**Proposal: Merimbula STP and Ocean Outfall Project – EIS Review**

Thank you for providing the EIS to DPI Fisheries for our initial comments.

FIGURE 2-4 : OCEAN OUTFALL PIPELINE – SECTION 2 (ABOVE SEAFLOOR)

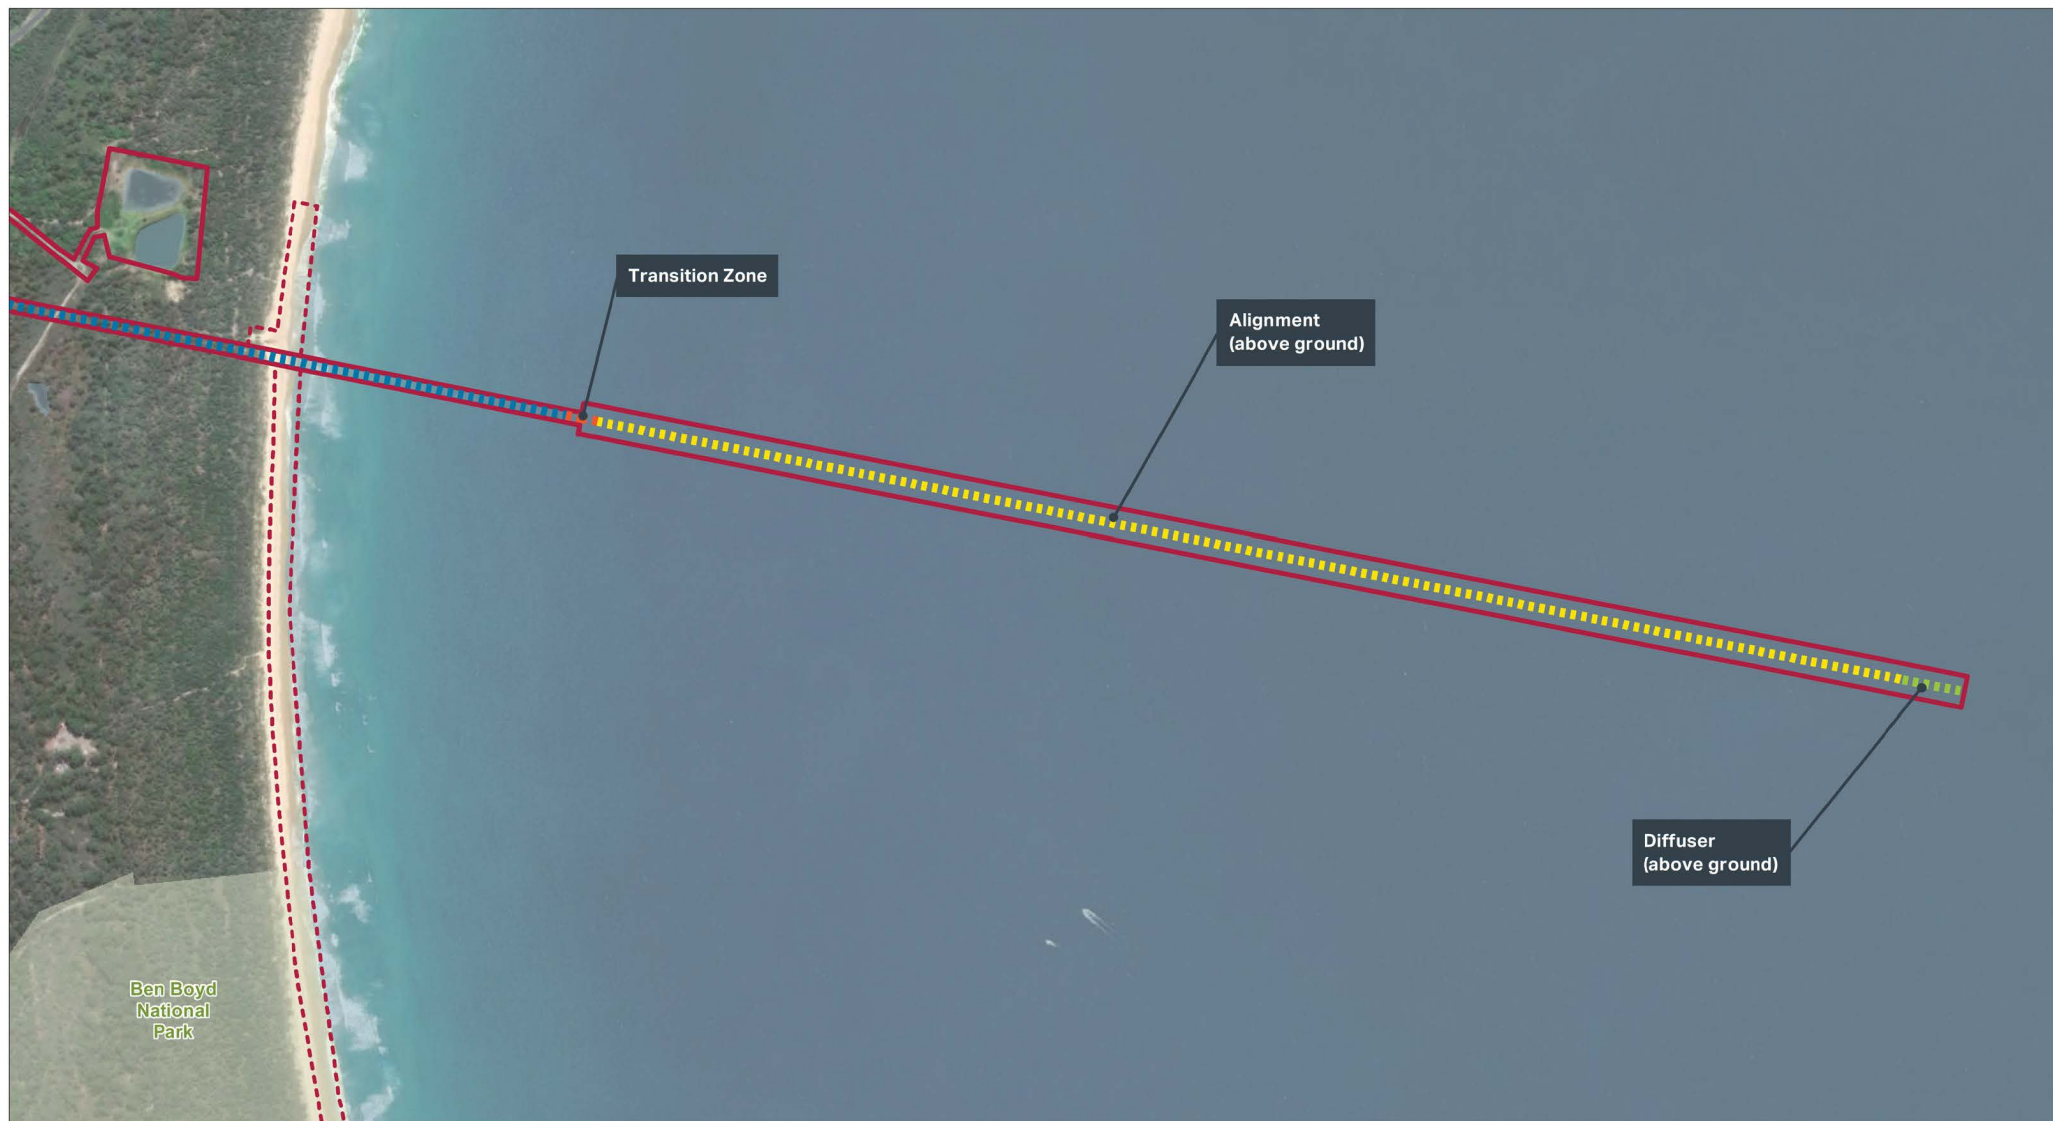
**Pipe Weighting**

Currently two options for weighting the pipe to the sea floor have been proposed, via concrete or rock mattress. Concrete structures offer very little complexity in habitat and are not as readily colonised by fouling and reef organisms. Large natural angular rock would provide a dual purpose of weighting the structure and providing complex rocky reef habitat and would support the statement in the EIS that the proposal would result in a long-term gain of Type 2, subtidal rocky reef fish habitat. This is the preferred option of the Department.
